**ZONING COMMITTEE  
RECOMMENDATION  
May 28, 2008**

**Rezoning Petition No. 2008-068**

- Property Owner:** Avtex Partners XI, LLC
- Petitioner:** Southern Holdings IV, LLC
- Location:** Approximately 11.05 acres located on the northeast corner of Eastfield Road and Highland Creek Parkway

- Center, Corridor, or Wedge:** Wedge
- Request:** R-9(PUD), single-family residential, Planned Unit Development to NS, neighborhood services
- Action:** The Zoning Committee voted to unanimously recommend **APPROVAL** of this request with the following modifications:

INTERIOR DRIVE CROSS SECTION B-B' SCALE: NTS

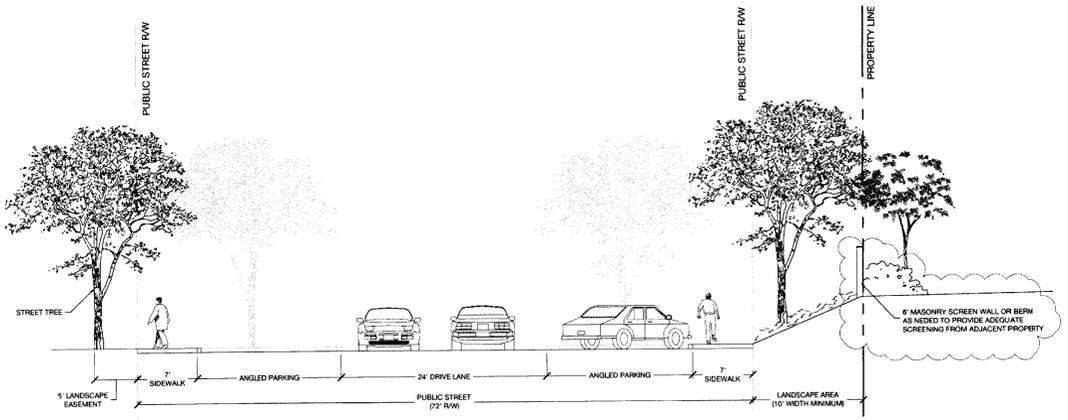
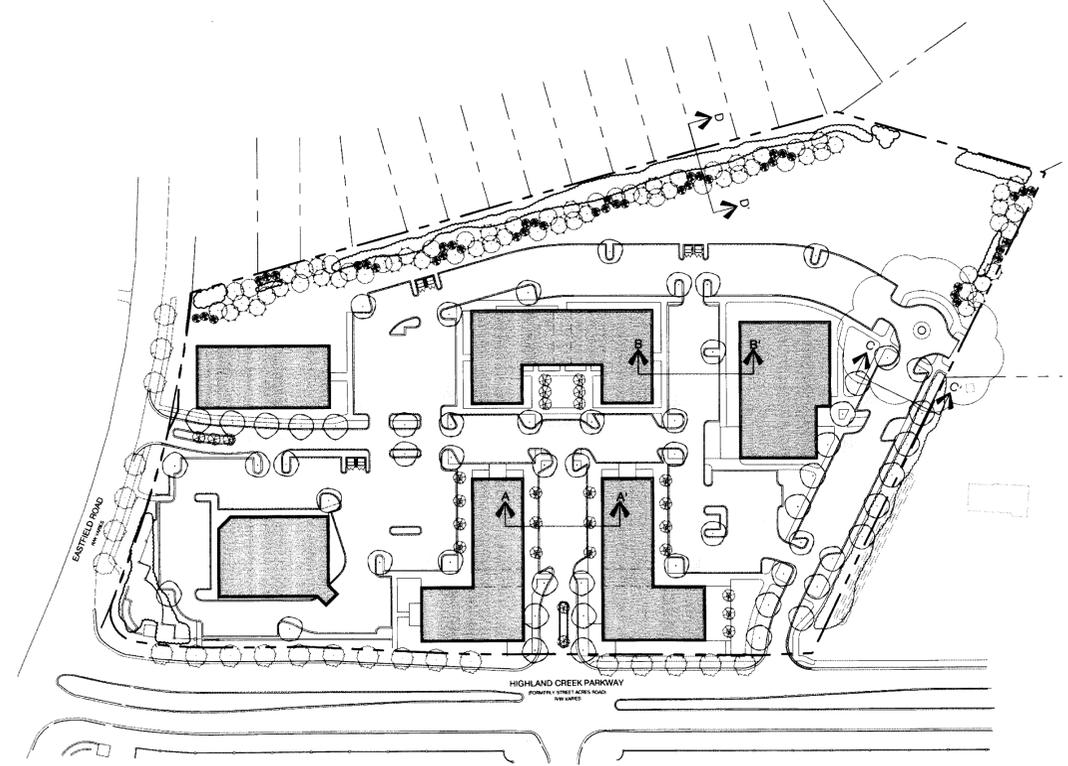
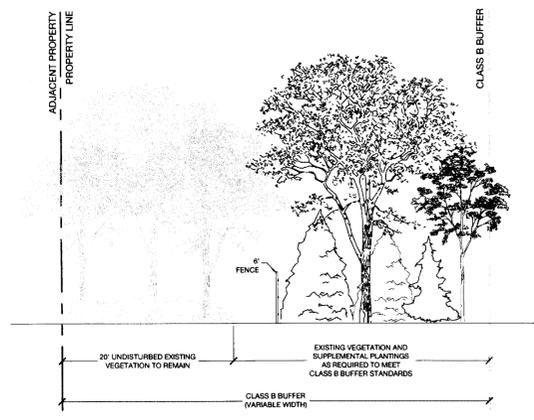
- The Petitioner and CDOT have agreed that the current location for the new internal public street is acceptable.
- The proposed public street will be designed and constructed to meet *Urban Street Design Guidelines* with the addition of angled parking. The final details to be worked out through the subdivision review process.
- Parking along the new public street will be located at least 100 feet from the Highland Creek Parkway and 20 feet from the end of corner radius of any intersecting street or driveway.

- The Petitioner met with Mr. Alan Buch and agreed to construct a berm and a six (6) foot brick wall (where the berm is not located) between the new public street and Mr. Buch’s property. Detailed drawings of this agreement are shown as a part of the conditional plan.

RZ-1

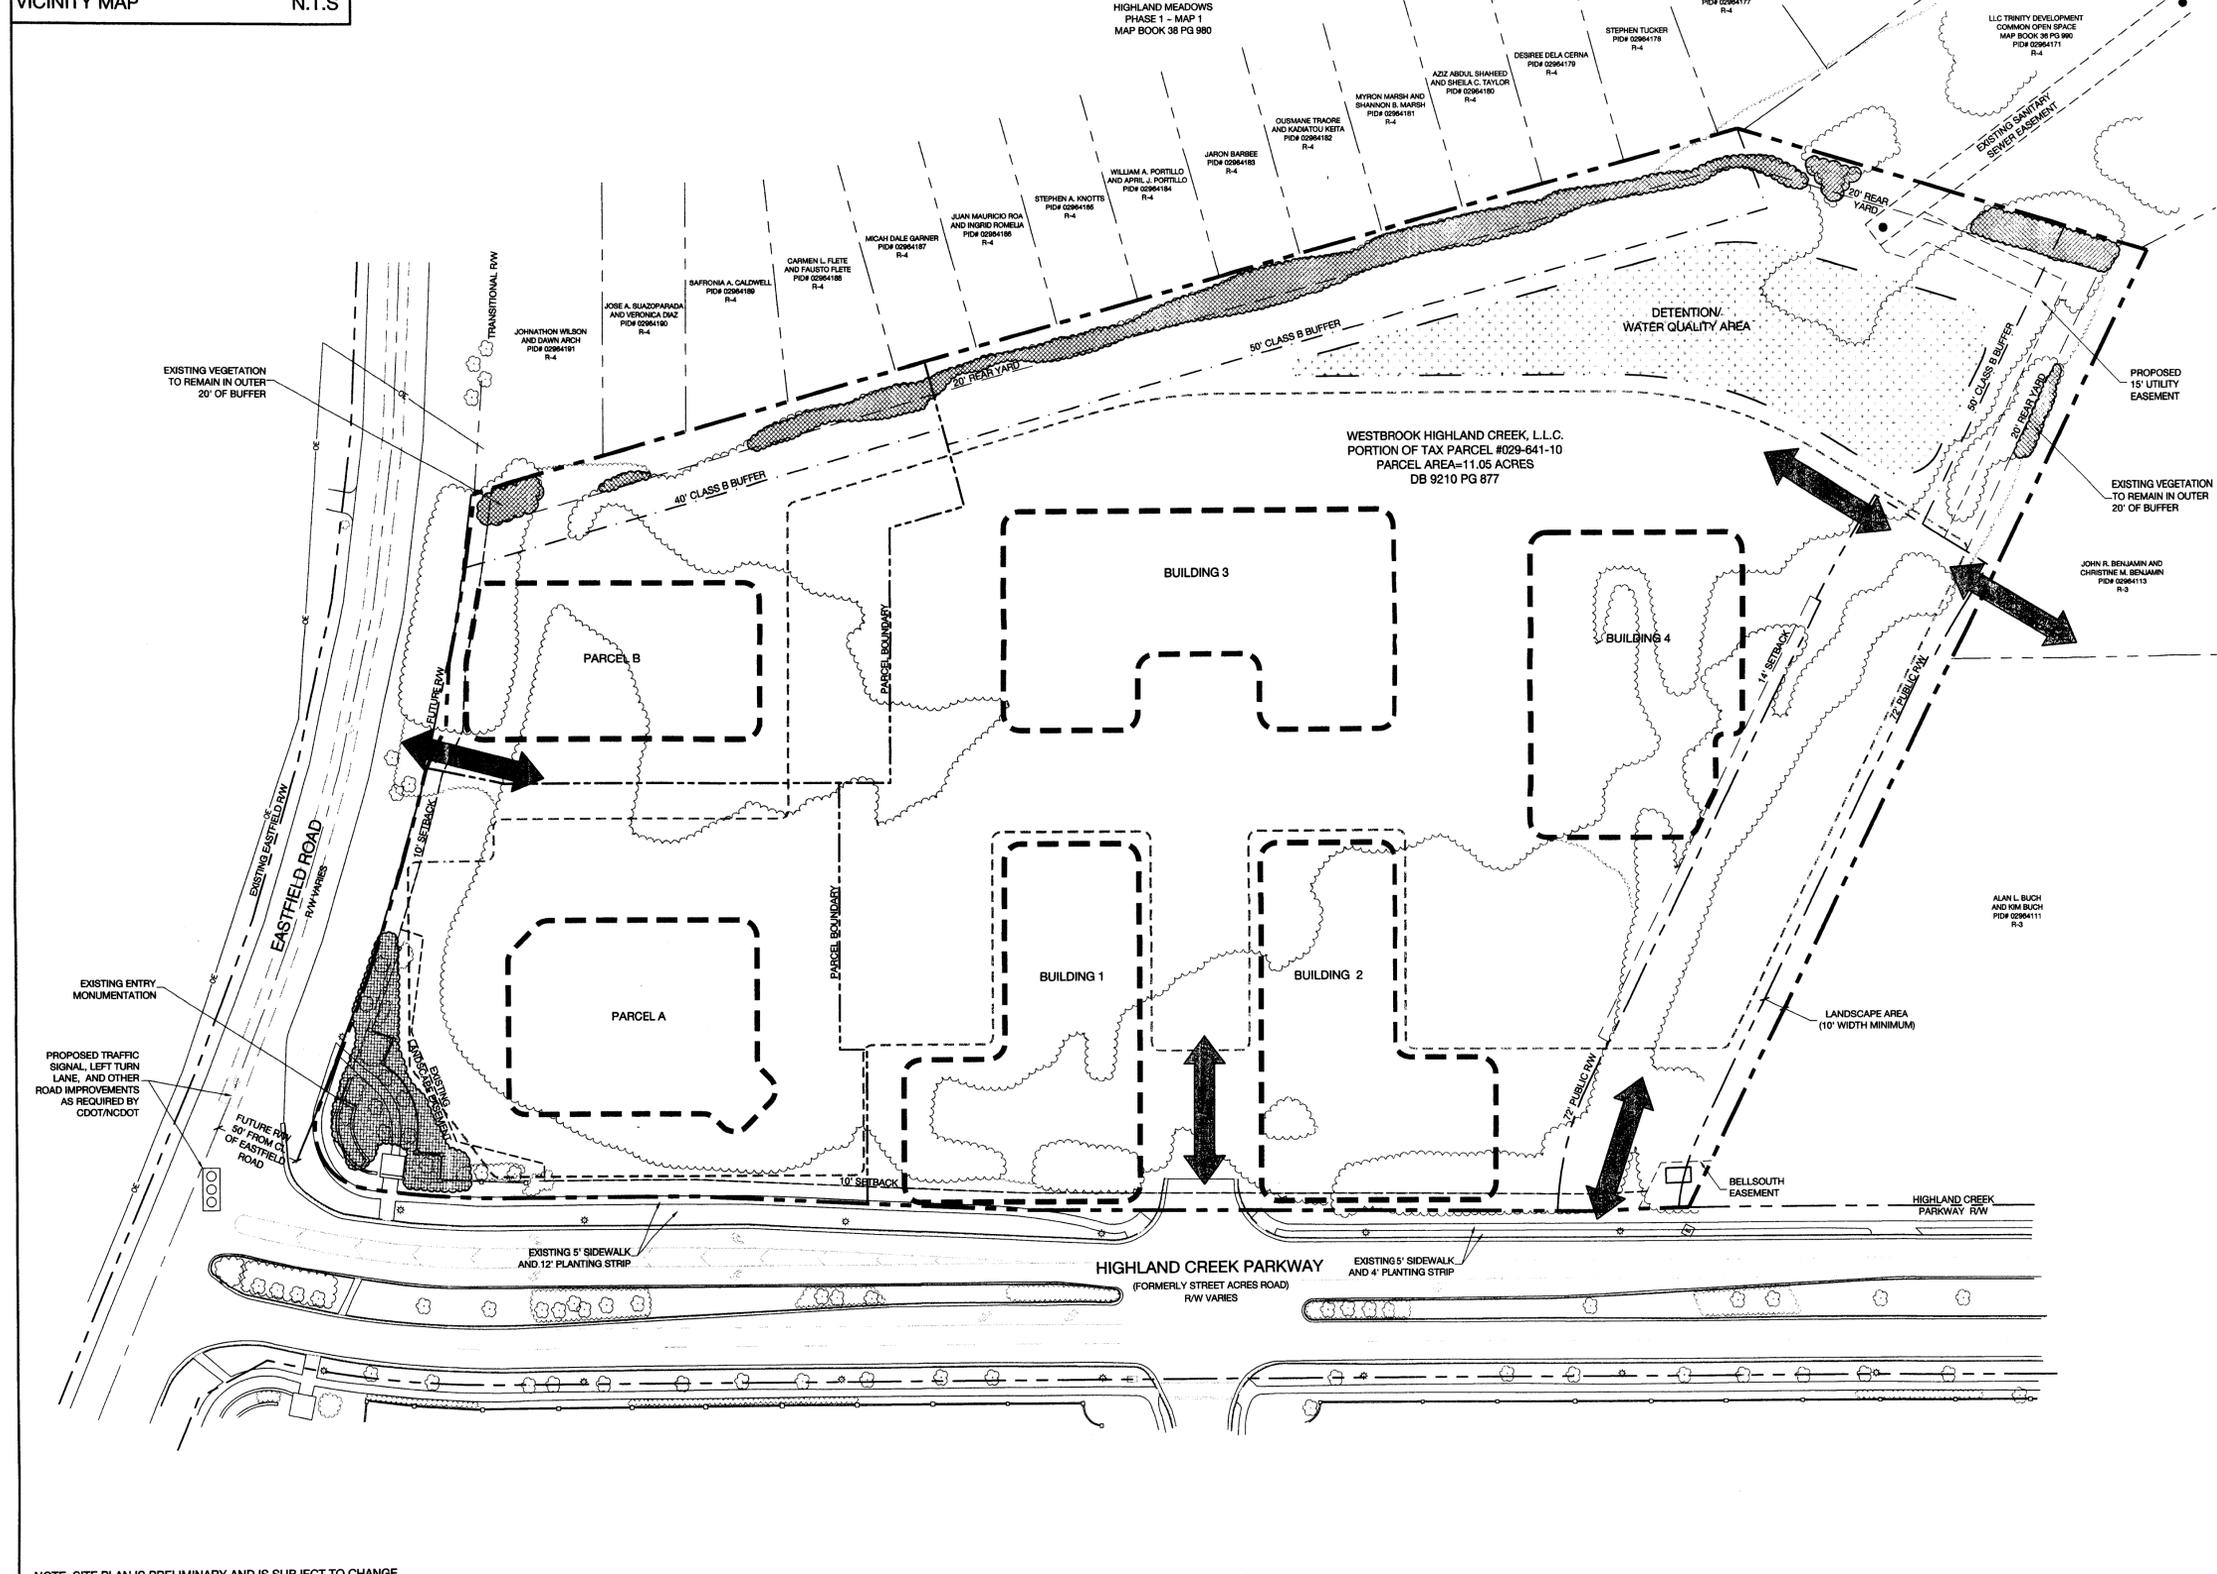
- The total number of parking spaces provided and how they were calculated will be added to the development summary. The total number of parking spaces provided is approximately 430 based on one space per 275 square feet.

- The maximum building height for the structures on the site will be added to the development summary. The maximum building height is 40 feet.
  - The Petitioner will replace the existing five (5) foot sidewalk along Highland Creek Parkway with a six (6) foot sidewalk.

- The site plan will be revised to indicate that the driveway on Eastfield Road will be limited to right-in/right-out unless the North Carolina Department of Transportation approves the driveway with the addition of a left-in access, at which time the driveway will be constructed to allow left turns into the Site from Eastfield Road.
- The Petitioner will remove from note 8b the wording regarding “mutual agreement”. The new Note will read that the design of the left turn lane is subject to the applicable CDOT and NCDOT standards.
- The Petitioner will be able to widen Eastfield Road asymmetrically as requested. Wording to that effect will be added to the Development Standards.
- The existing five (5) foot sidewalk along Eastfield Road will be replaced with a six (6) foot sidewalk.

- A note was added to the plan restricting construction access to the site to Eastfield Road subject to approval by the appropriate review agencies.
- The height of the masonry screen wall along Highland Creek Parkway and Eastfield used to screen the parking spaces on Parcel A was increased in height from two (2) feet to three (3) feet.
